Proposal: Substitution of drawings to allow the removal of a Category C tree, referenced as T1158 on the previously approved landscaping and replacement planting (proposed as Non Material Amendment of 16/02446/F)

2.1. This application seeks a Non-material Amendment (NMA) to planning reference 16/02446/F.

2.2. The proposed NMA comprises two parts – (1) the removal of 1no 'category C' Silver Birch (ref: T1158) tree, located close to the western boundary of the site, adjacent to the bridleway; and, (2) the planting of 2no Field Maples trees to the north of T1158, as replacement for the tree being removed.

Title: Detailed Tree Planting Proposal

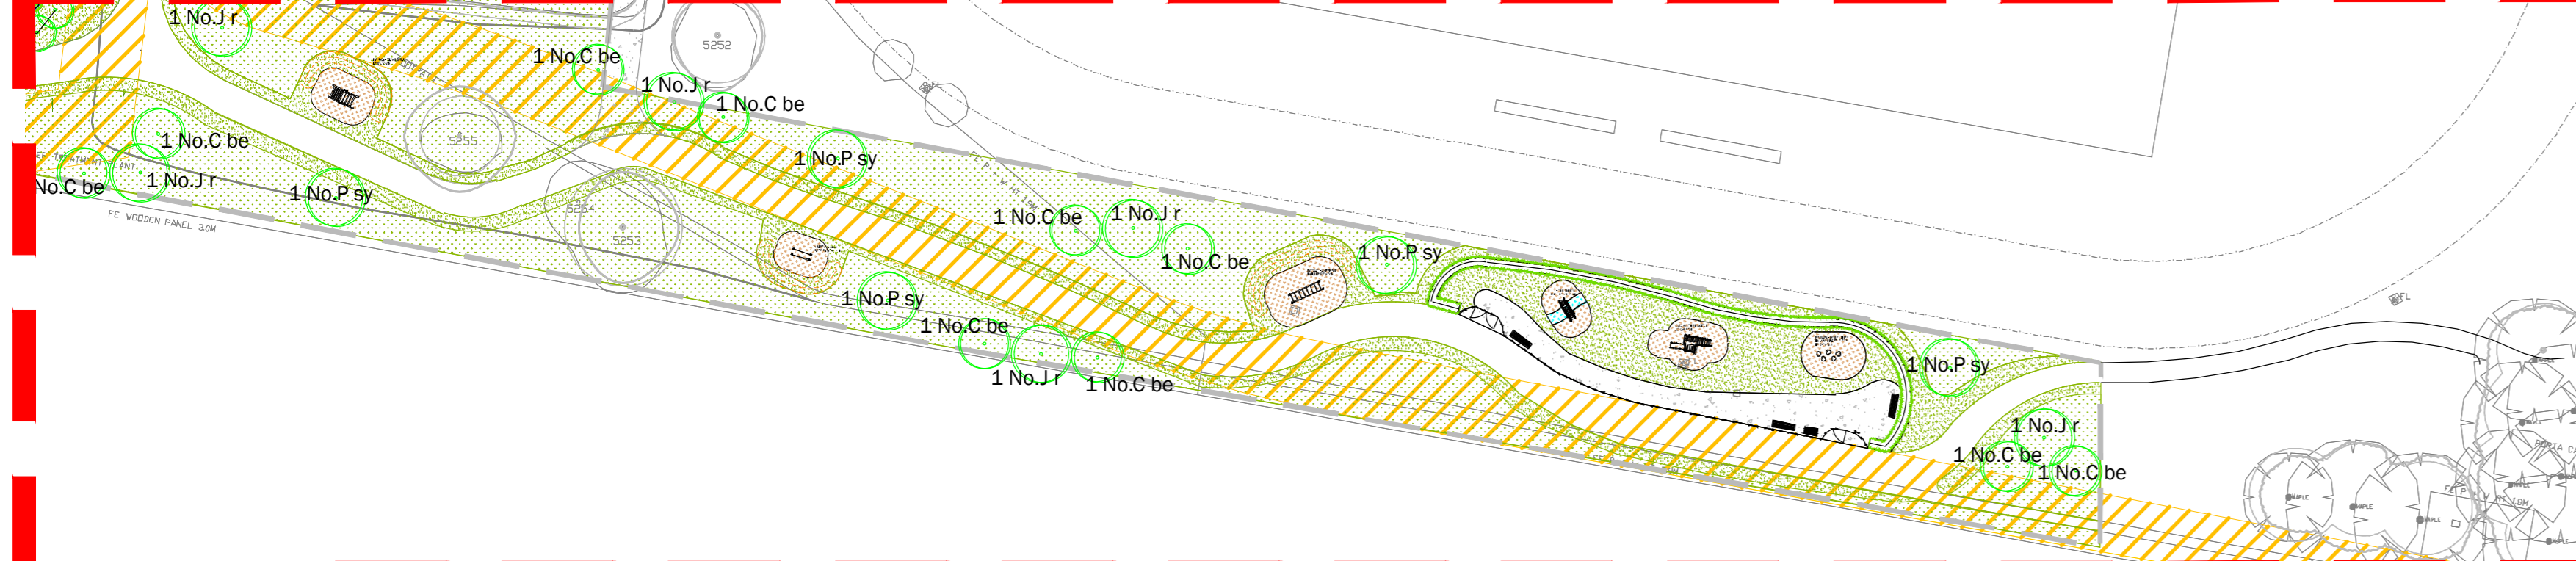
- 5.5. It is understood that a detailed engineering assessment has been undertaken wherein the applicants supporting submission states that the subject Silver Birch tree lies in *‘close proximity to extensive fixed surface infrastructure’*. The supporting submission goes on to highlight the route of the existing surface water sewer and the single potential alternative route to avoid the Silver Birch. However, it is stated that the alternative route considered was not feasible from a construction perspective as the substantial trench block required and diameter of surface water pipes would severely damage the roots of the Silver Birch in any case. As such, the removal is proposed.

- 5.6. The subsequent replacement trees (i.e. 2no Field Maples) would be planted just to the north of the Silver Birch, beyond the highlighted drainage easement area, to mitigate the potential loss.

- 5.7. Significantly, the intended ‘pleasant environment’ for the development, inclusive of a strong and meaningful landscaping scheme, would be retained and reinforced. The loss of the single Silver Birch would represent a minor change, having no tangible effect on the planning permission as originally granted, particularly with the replacement planting now proposed.

- 6.1. The proposal is considered to be non-material and the application is therefore recommended for approval.
